WEST SUSSEX COUNTY COUNCIL CONSULTATION

TO:	Arun District Council FAO:Ms A Gardner
FROM:	WSCC - Highways Authority
DATE:	6 November 2020
LOCATION:	Scorton 9 Limetree Close Littlehampton BN16 1JA
SUBJECT:	EP/133/20/DOC Approval of details reserved by condition imposed under ref W/4000721 (EP/148/19/PL) relating to Condition Nos 4 - landscaping, 5 - provision of nest boxes, 7 - site set up, 8 - surface water drainage, 9 - maintenance & management of surface water drainage, 11 - materials, 13 - car parking & pedestrian walkway and 14 - cycle parking.
DATE OF SITE VISIT:	n/a
RECOMMENDATION:	No Objection
S106 CONTRIBUTION TOTAL:	n/a / £ See below for breakdown.

Discharge of conditions

The Pure Group	
drawing	LTC.SETUP.001
project	Limetree Close East Preston
Site Set Up	
Scaled at 1:200 on A3 ~ April 2019	
Drawn by: AM The Pure Group

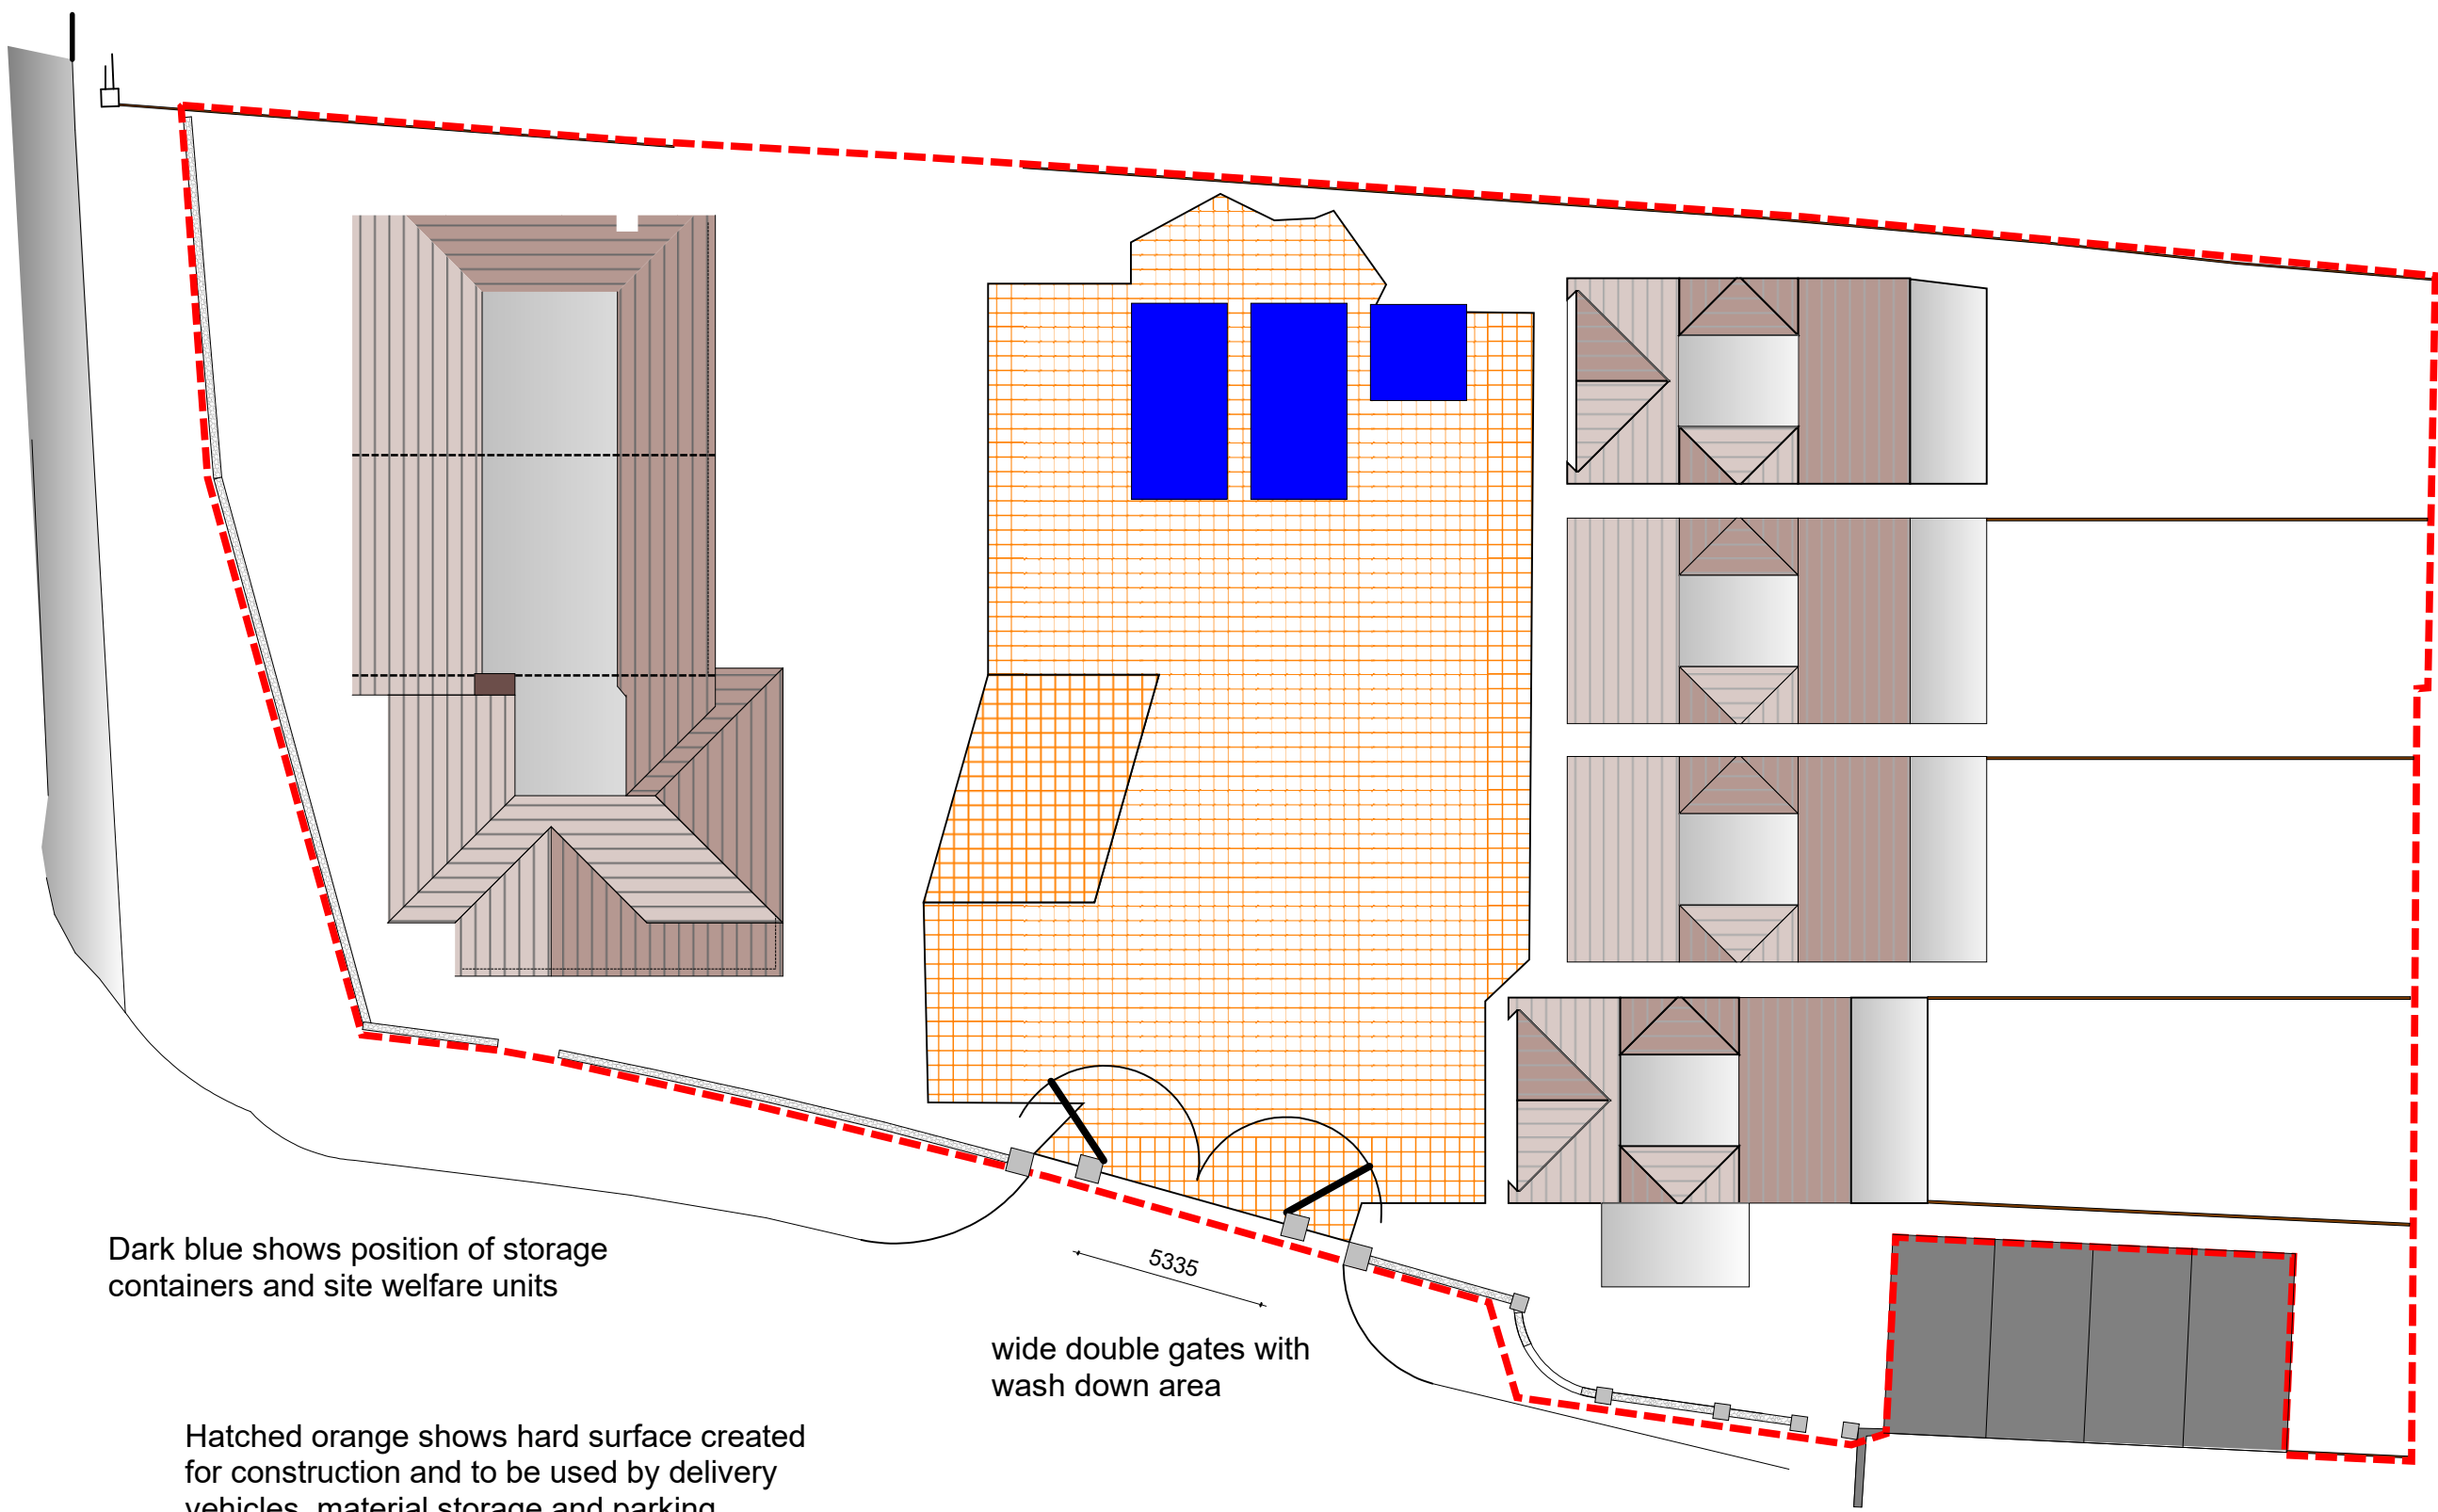
Plan: Site Set up - LTC.Set up.001

Condition 7 - Site Set Up, can be discharge as per the submitted drawing
